Project Title: Applebee's -- Montano Plaza Building Permit #: \_\_\_\_\_ City Drainage #: E12/D003A

**Re: Applebee's- Montaño Plaza, 6200 Coors Blvd.  
Certificate of Occupancy – Transportation Development  
Site Development Plan dated 06-02-14 (E12-D003A)  
Certification dated 11-03-14**

**Re: Applebee's- Montaño Plaza, 6200 Coors Blvd.  
Submittal for Certificate of Occupancy – Transportation Development**  
Engineer's Stamp dated 05-19-14 (E12-D003A)  
Certification dated 11-03-14

site plan for building permit

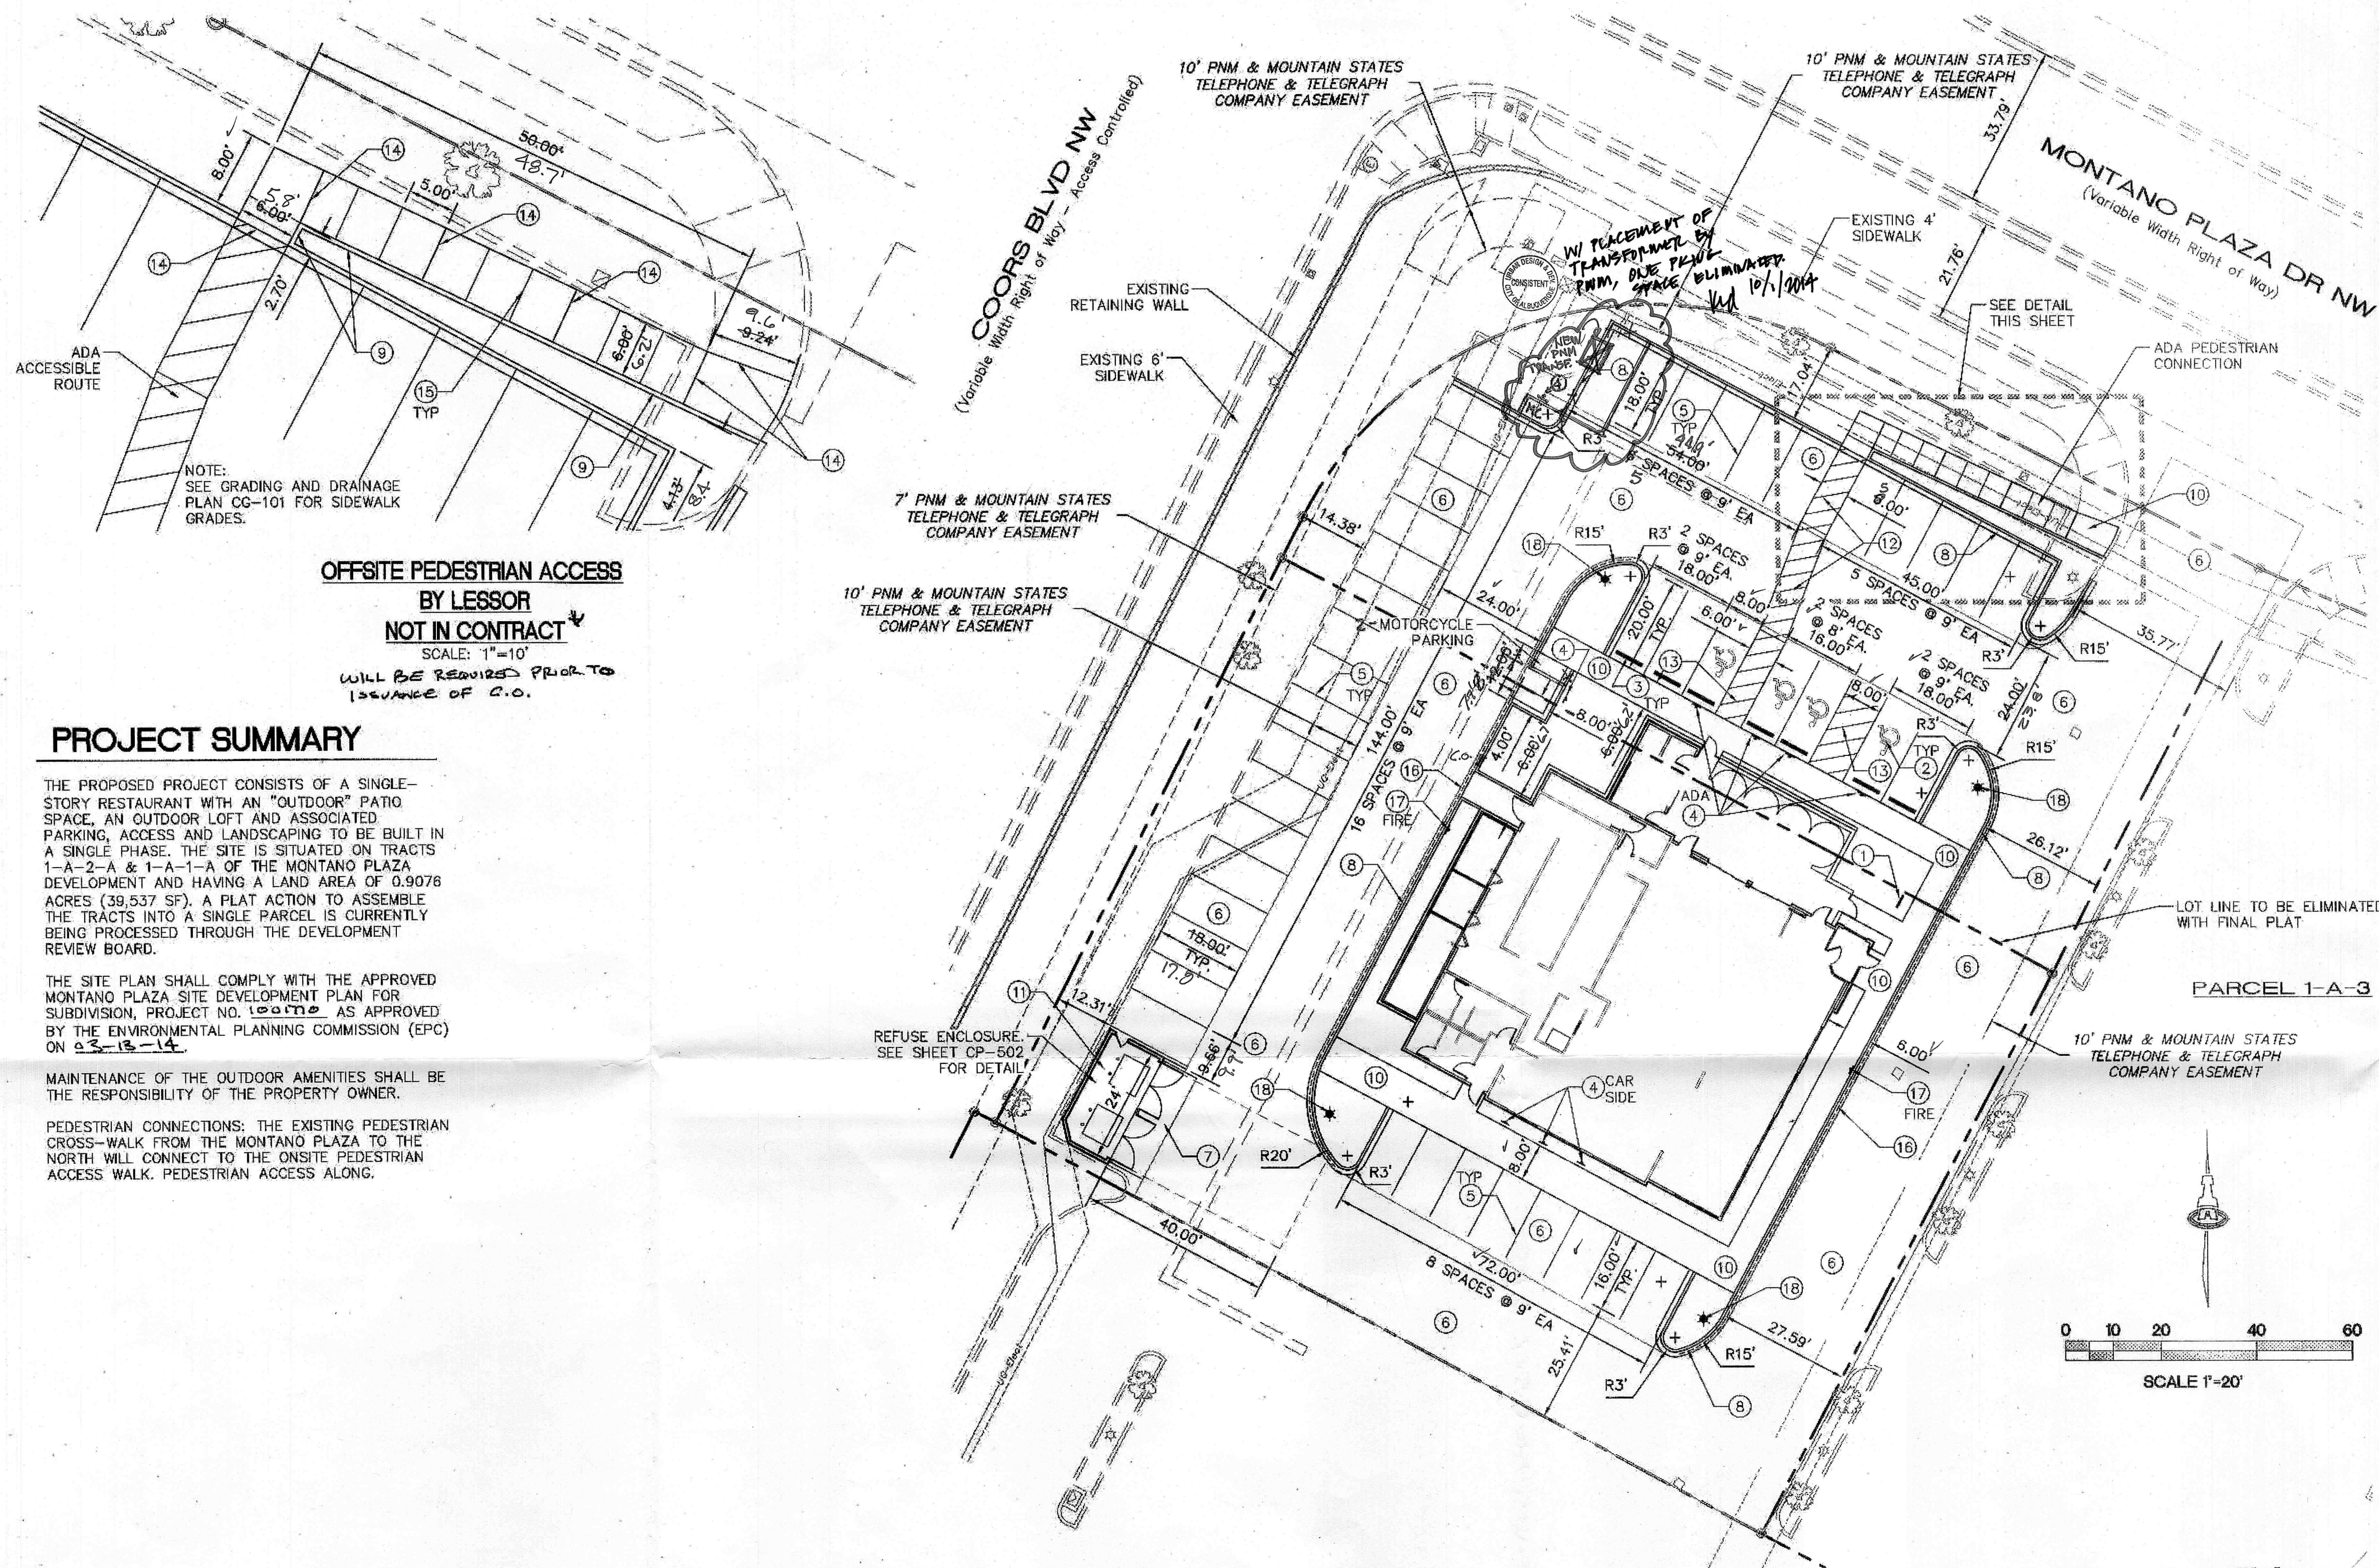
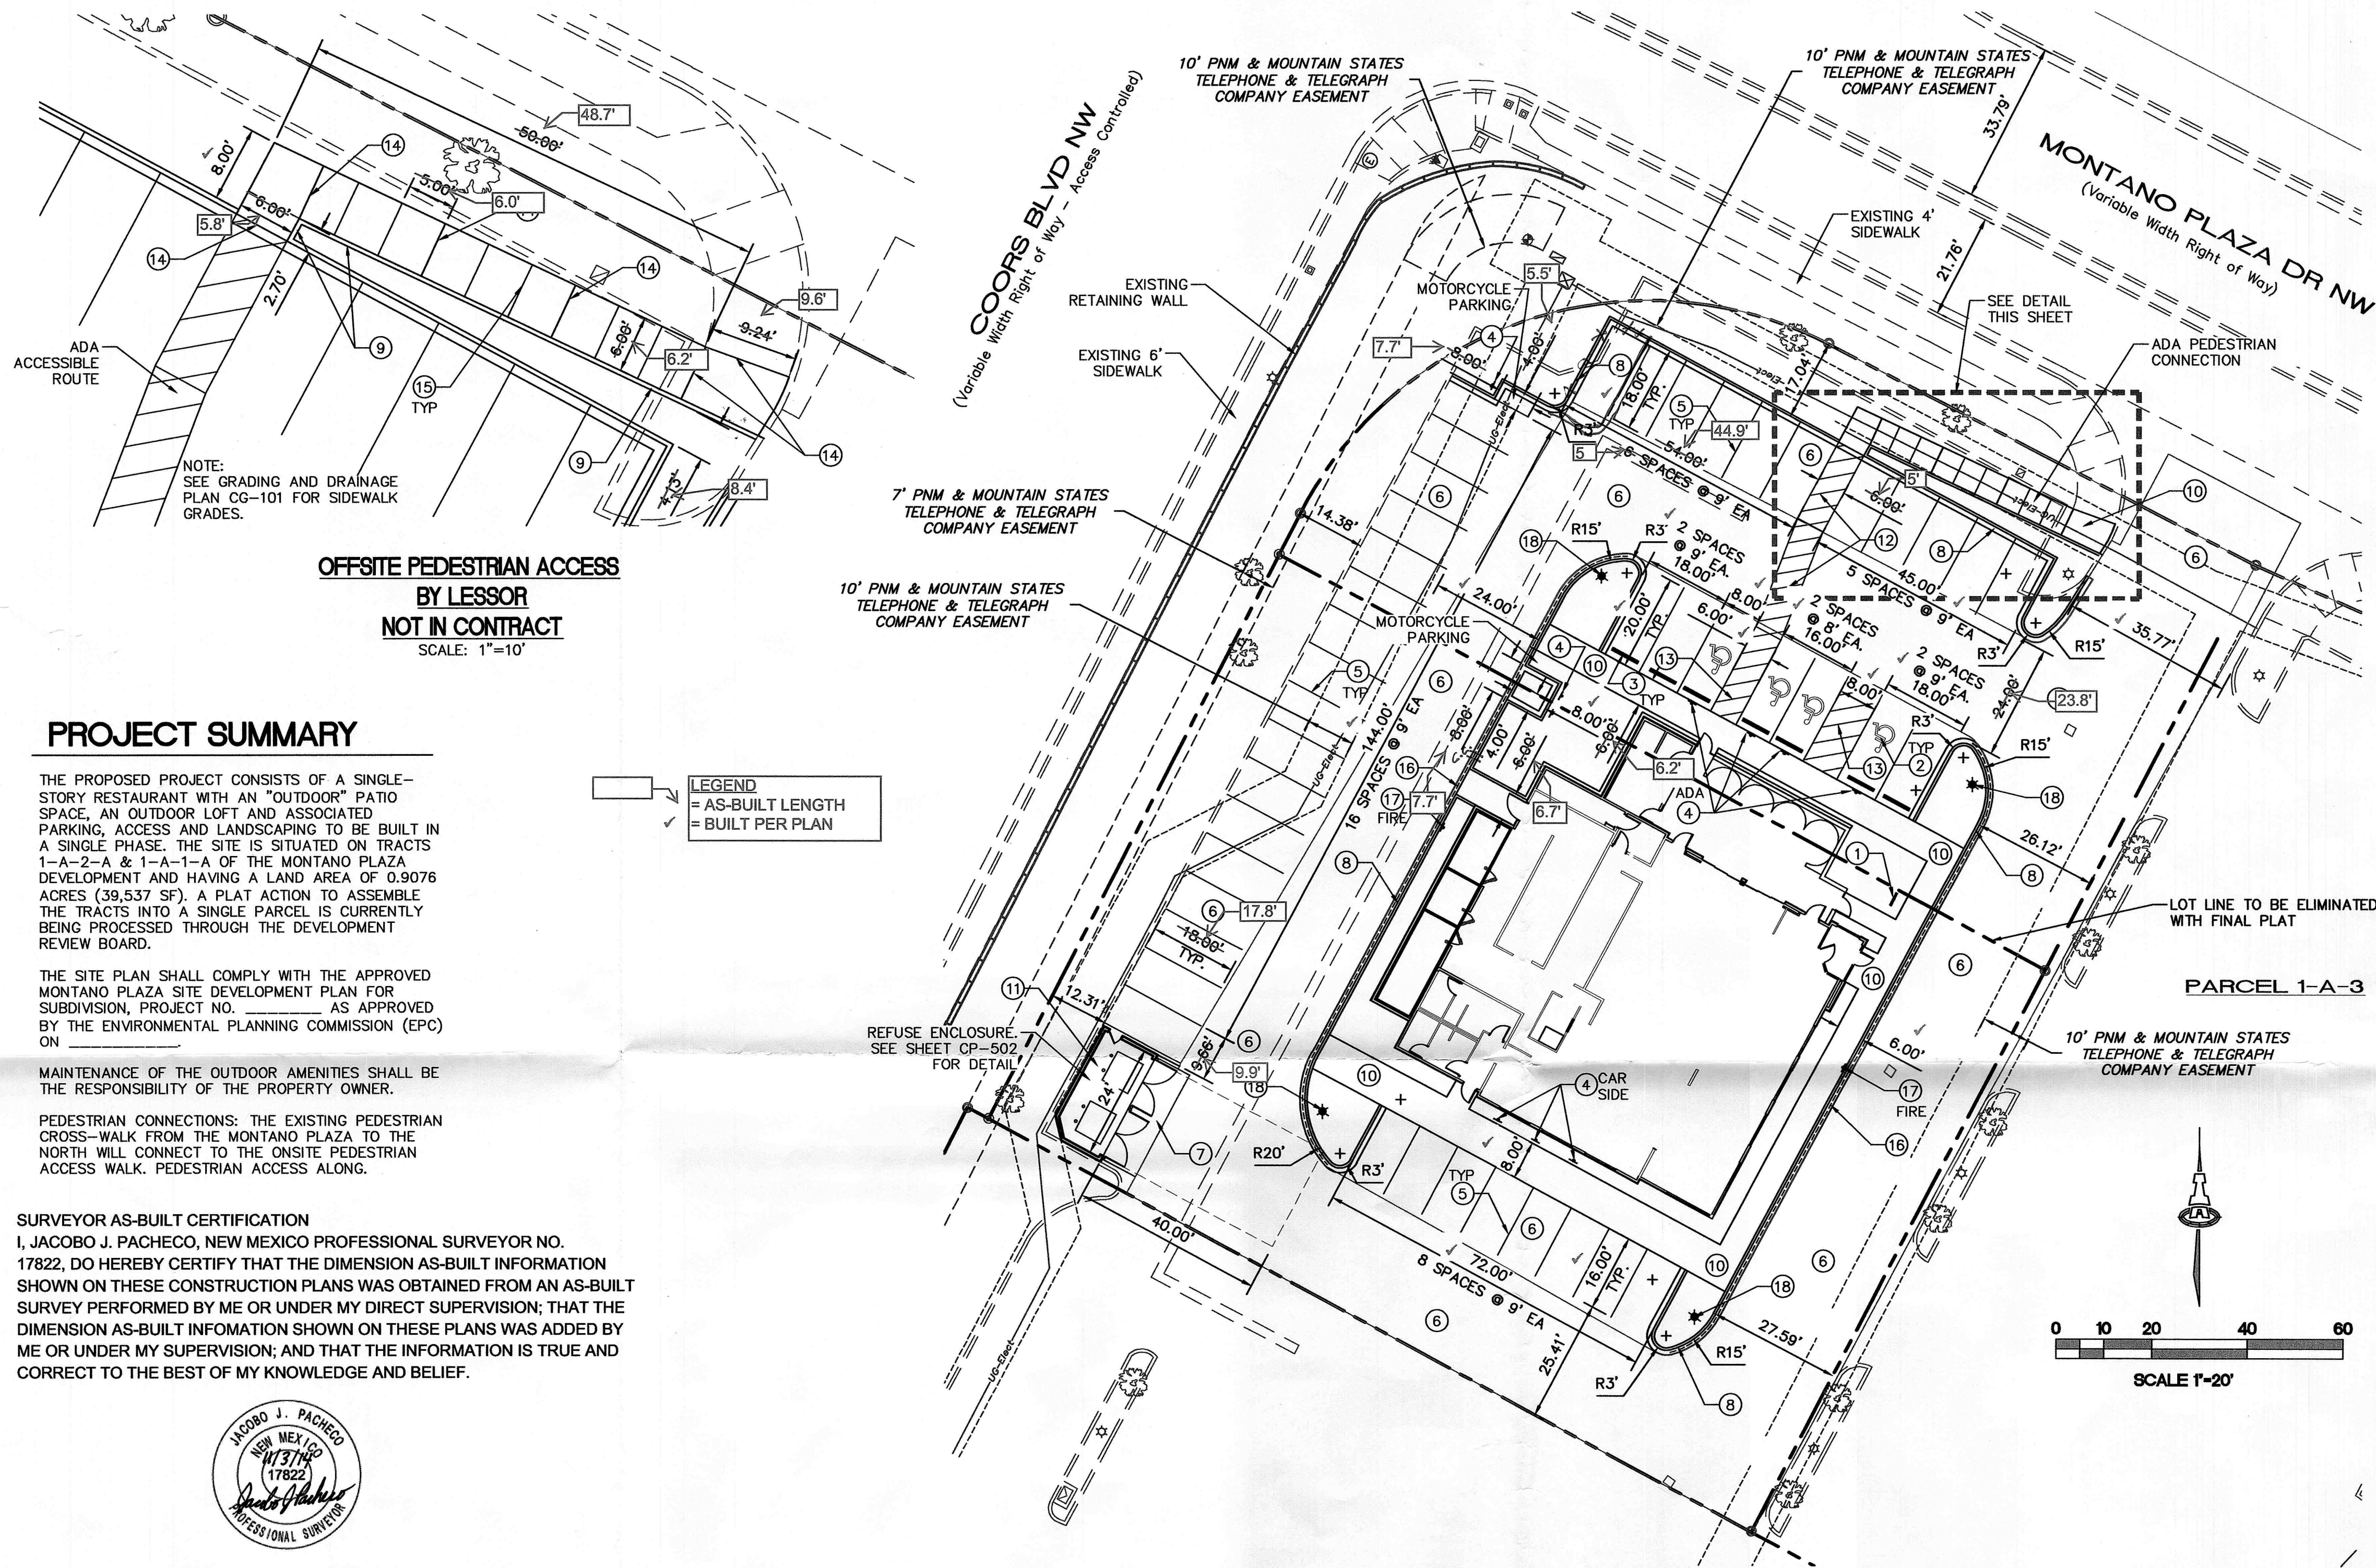
The Letter of Certification submitted on 11-10-14 is not sufficient for acceptance by this office for final Certificate of Occupancy (C.O.). The following items need to be addressed:

- The DRB Site Plan (or most recent AA) submitted for Final C.O. needs to be the latest edition, which may have redlined comments, initialed and dated by the designer-of-record.
- Engineer's Certification language needs to certify the transportation improvements rather than the hydrology improvements.
- The site needs to be cleared of construction materials and equipment.
